### RE: Clint Short Plat (SP-08-00054)

The Kittitas County Community Development Services Department has determined that the Clint Short Plat (SP-08-00054) is a complete application and hereby grants *conditional preliminary approval* subject to the following conditions:

SHORT PLAT NO. _____
KITITAS COUNTY, WASHINGTON

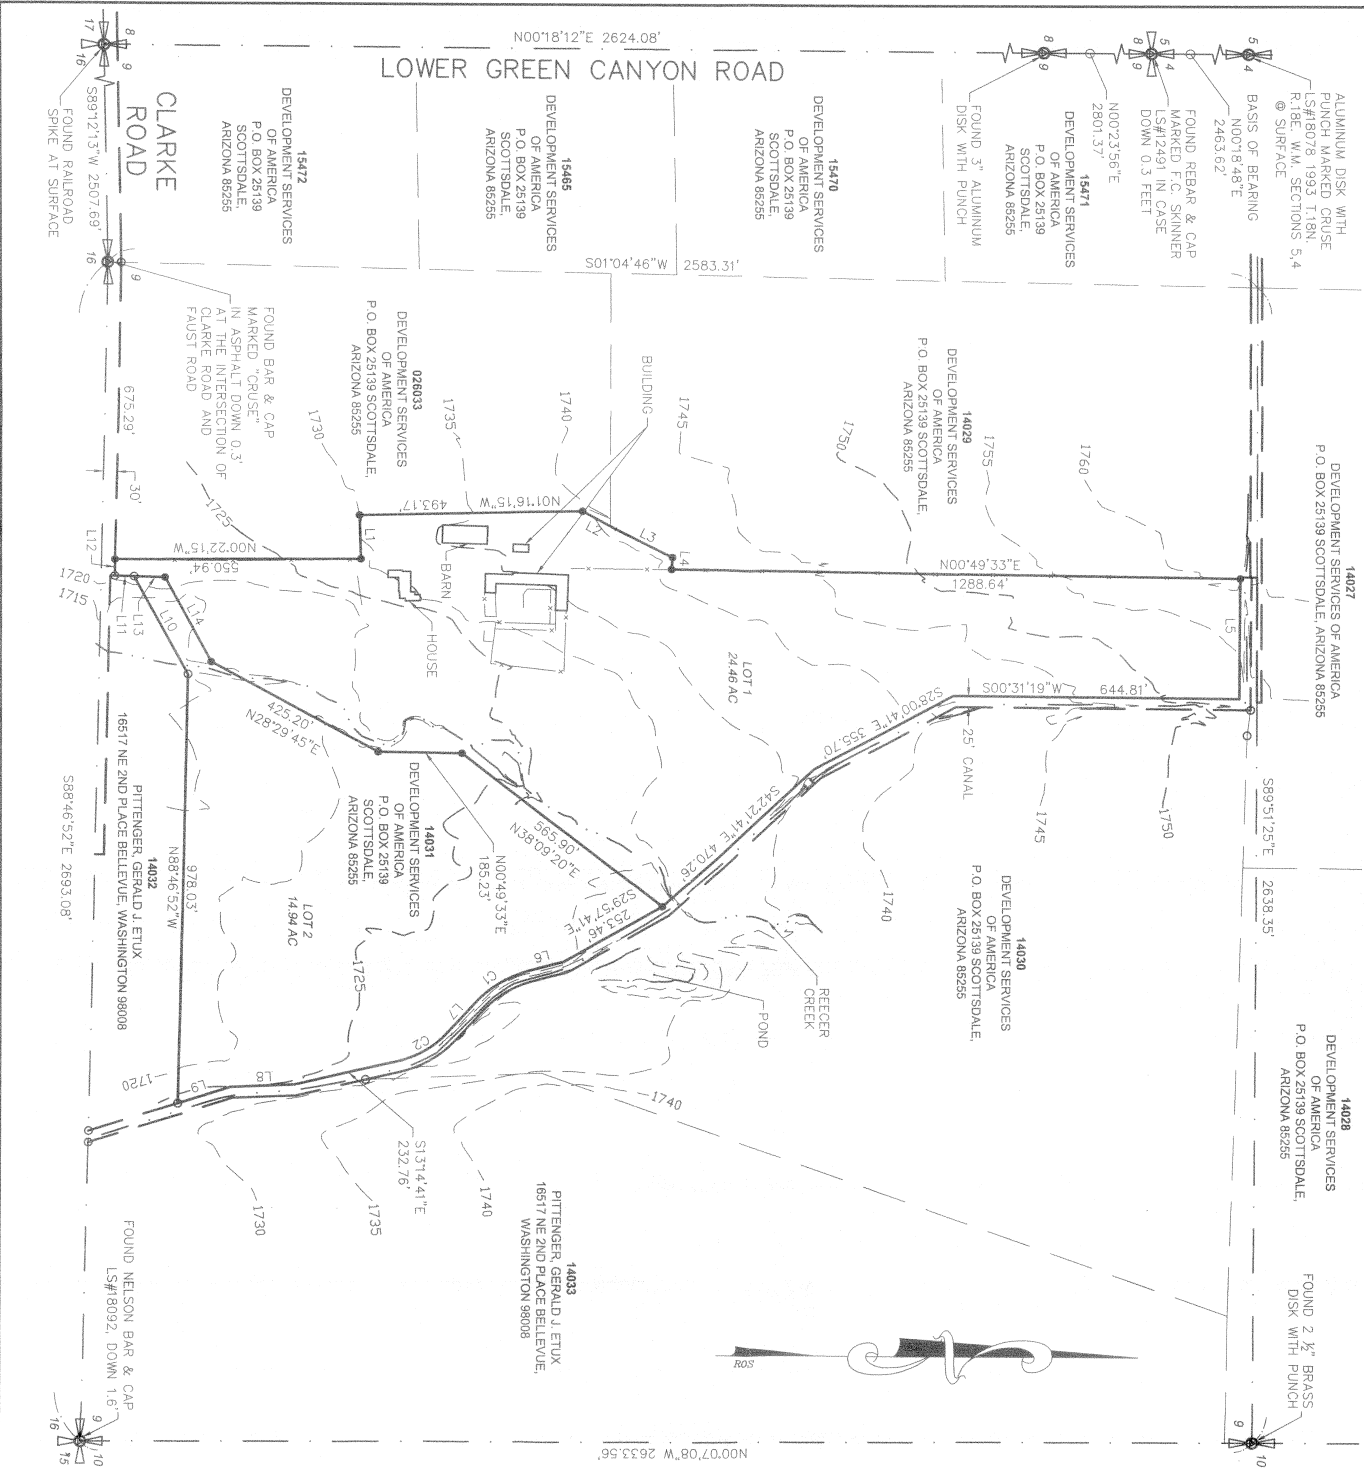
1. Both sheets of the final mylars shall reflect short plat number SP-08-00054 and an accurate legal description shall be shown on the face of the final plat.

10. Portions of both proposed parcels in the Clint Short Plat are shown on FEMA Flood Insurance Rate Map Panel 5300950437B as being within the 100 year Floodplain. As per KCC 17A.05.015, all preliminary plats must clearly delineate the one-hundred-year floodplain boundary, according to the FEMA Flood Insurance Rate Map. Any future development occurring within the designated Floodplain shall be subject to the regulations established in KCC Chapter 17A.05 (Ord. 93-18 by reference).

11. Lot 1 of the Clint Short Plat has PEMC and PUBHx wetlands across the west end of the property. The final mylars shall reflect the location of these wetlands and a statement on the plat shall read as follows: "Future development of lots may require a study by a certified wetland biologist to determine wetland classification and for buffer requirements pursuant to KCC Critical Areas Code."
